29 August 2008

NSW Department of Planning
Strategic Sites & Urban Renewal
Director Strategic Assessments - Mr Michael File
GPO Box 39,
SYDNEY, NSW, 2001

**Part 3A - Project Application (Application No. MP 07_0099)
Potts Hill Sydney Water Redevelopment by Landcom (Bankstown LGA)**

ROAD LONGITUDINAL SECTIONS
MC03 CH 0 TO 600

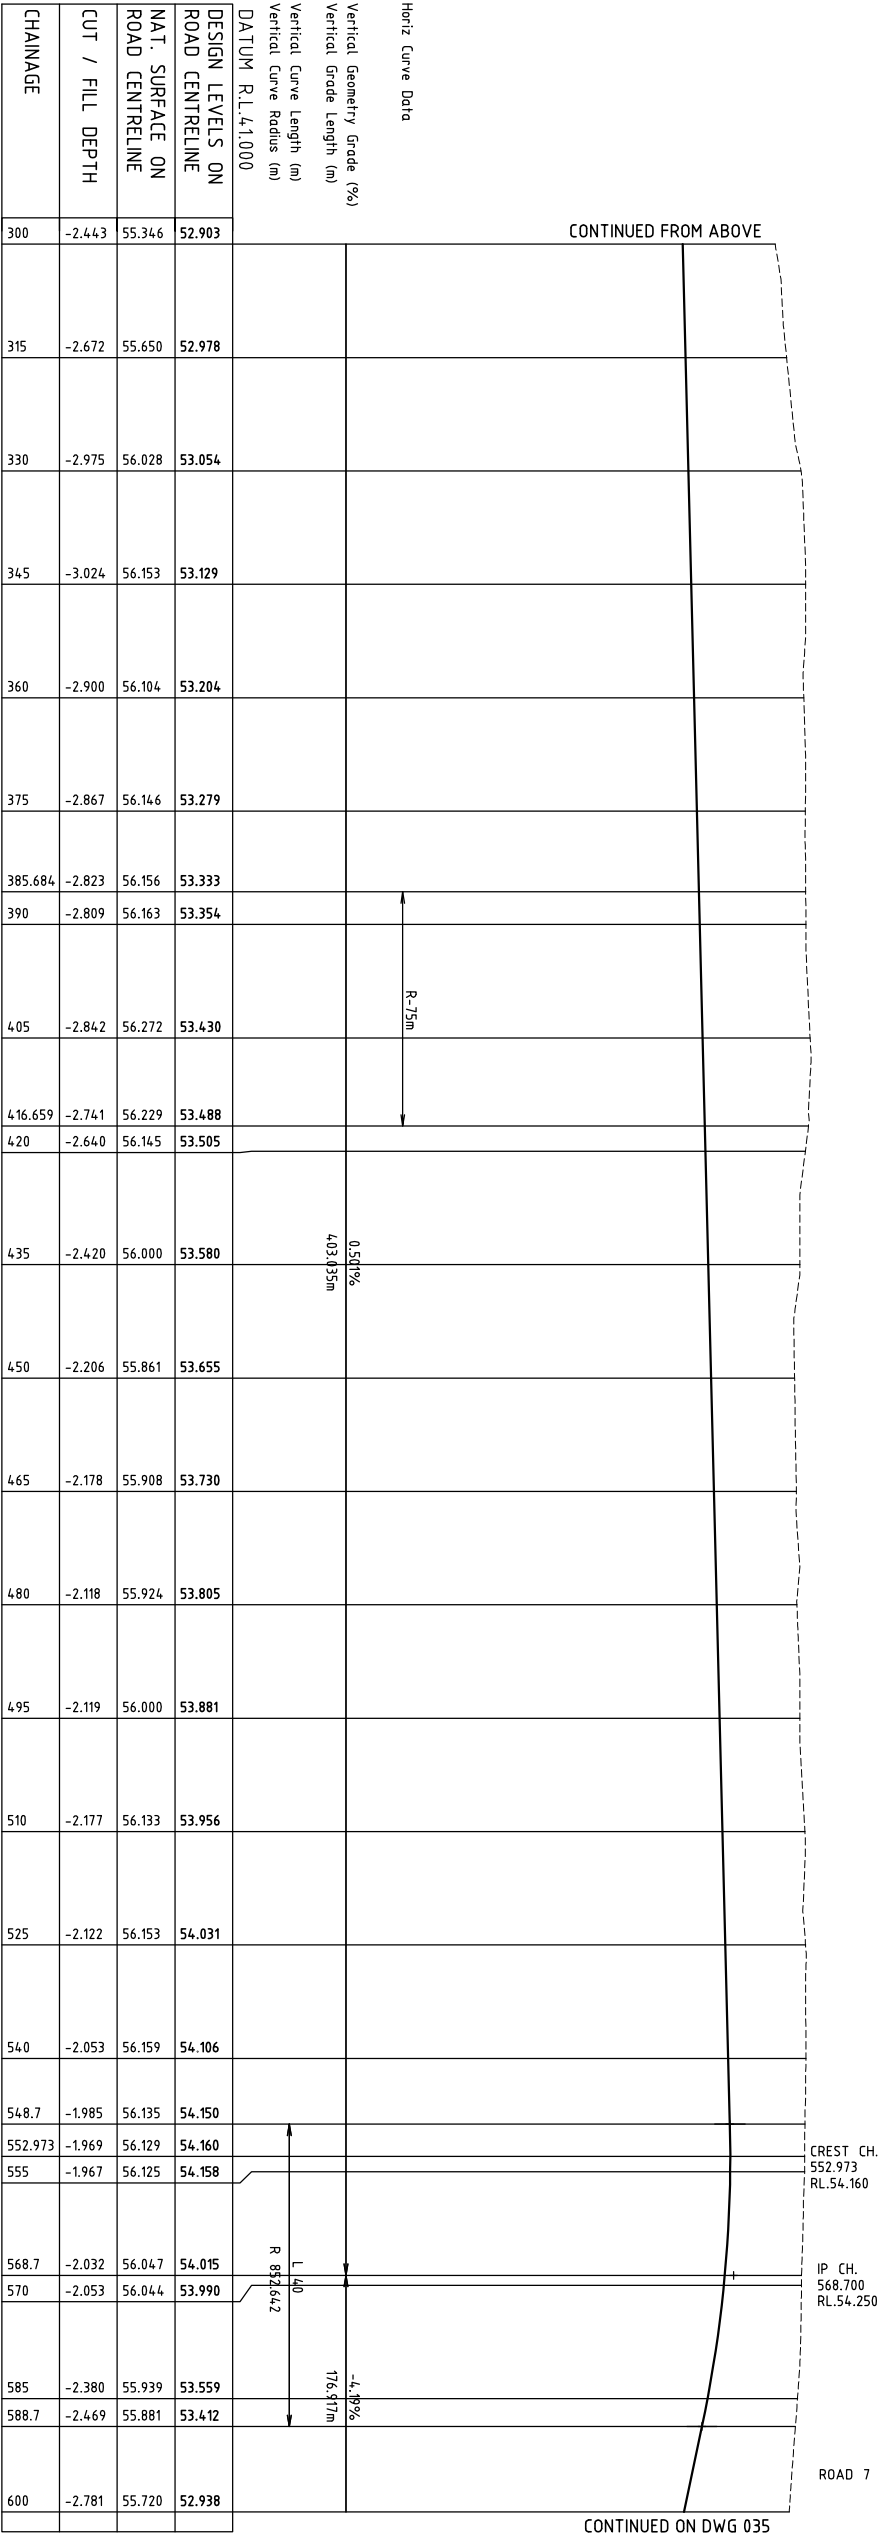
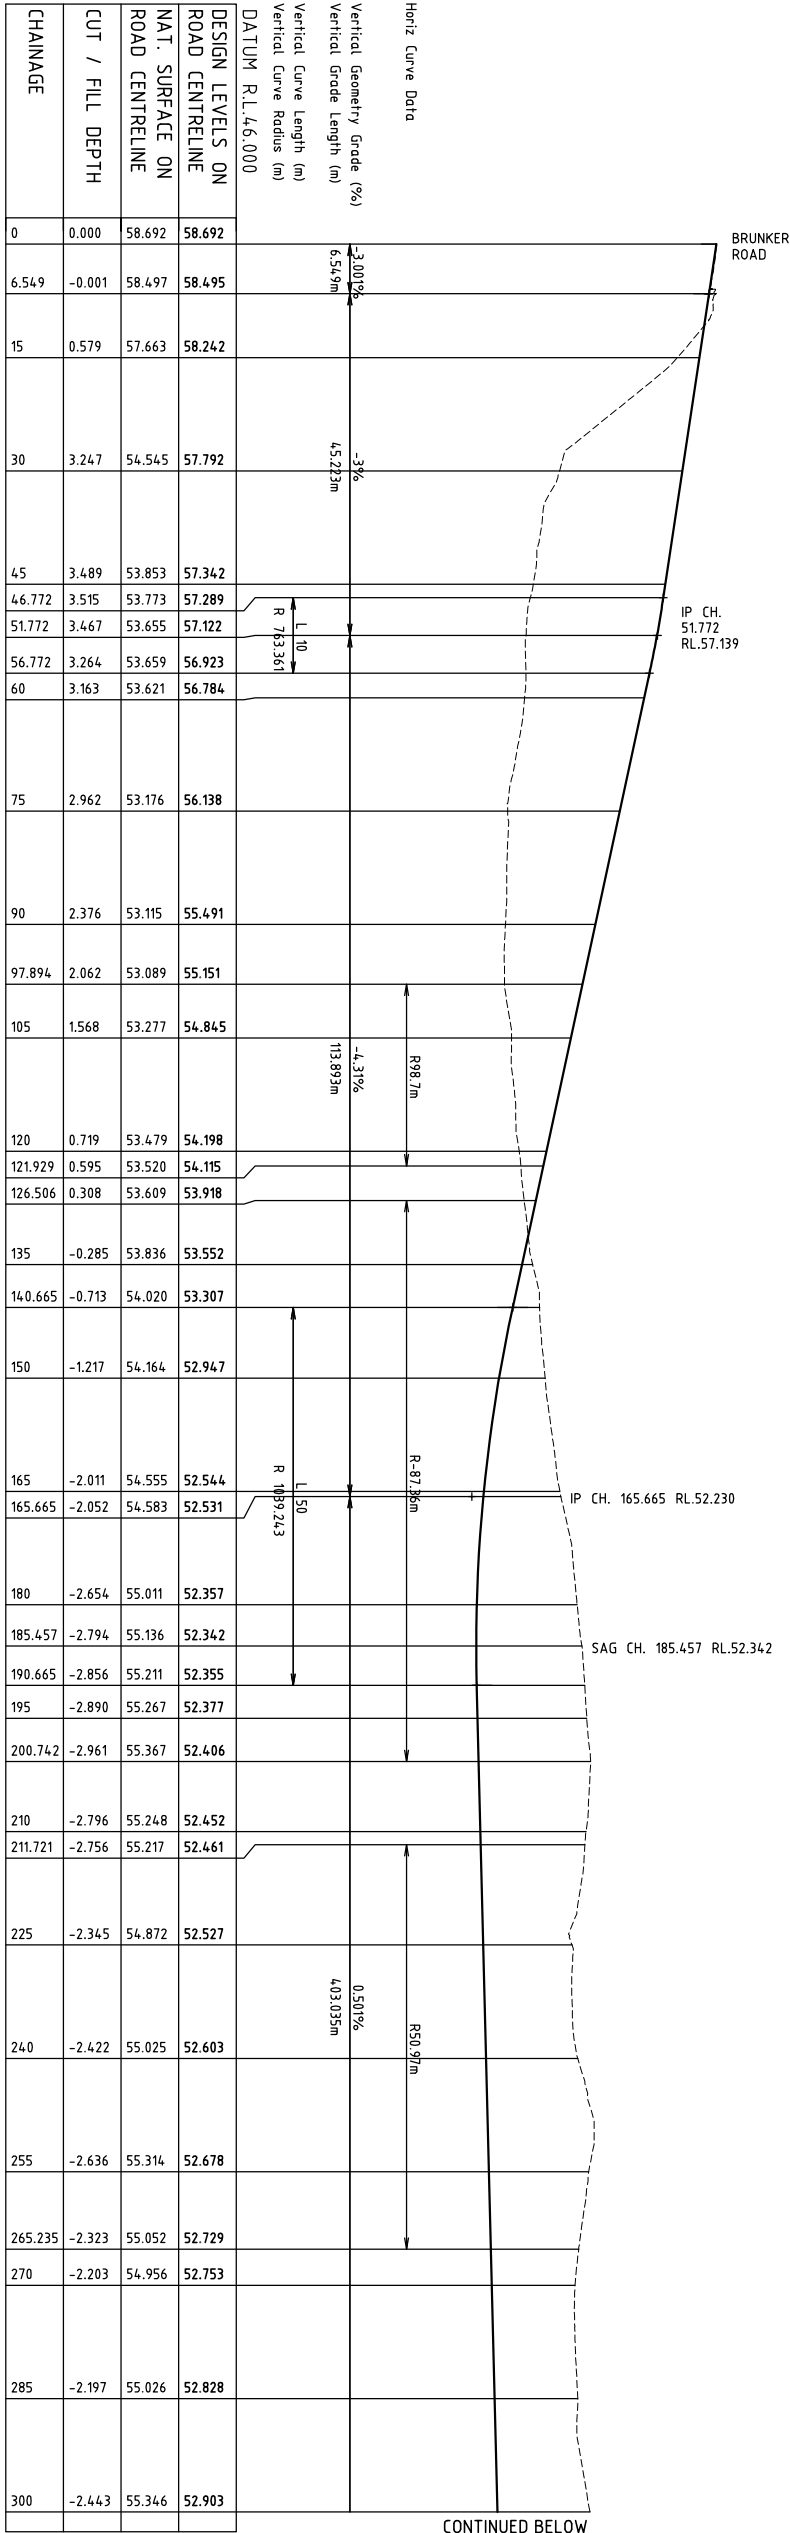
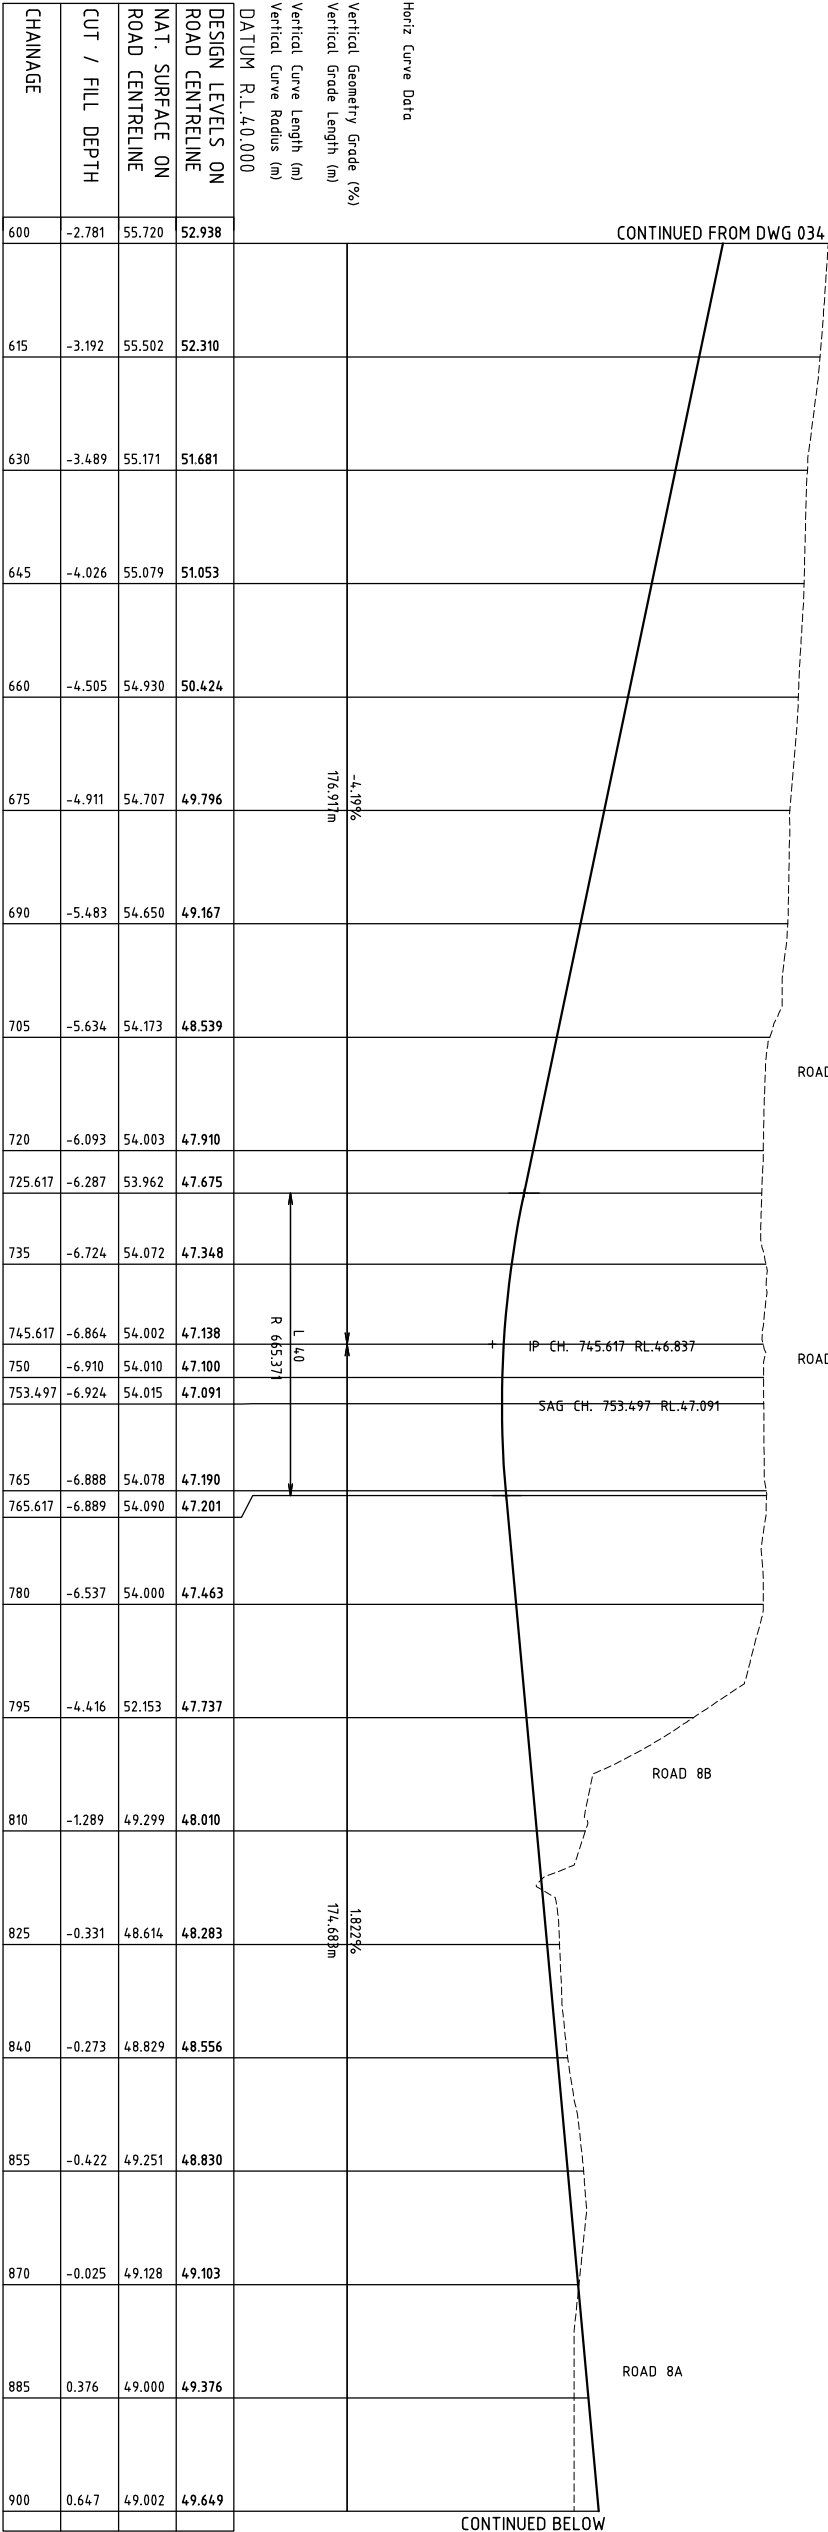
2.2.3.1 The internal road layout contains a number of straight road sections, which will promote excessive speed. The proposed streets should be designed to limit vehicle speeds to less than 40 km/hr.
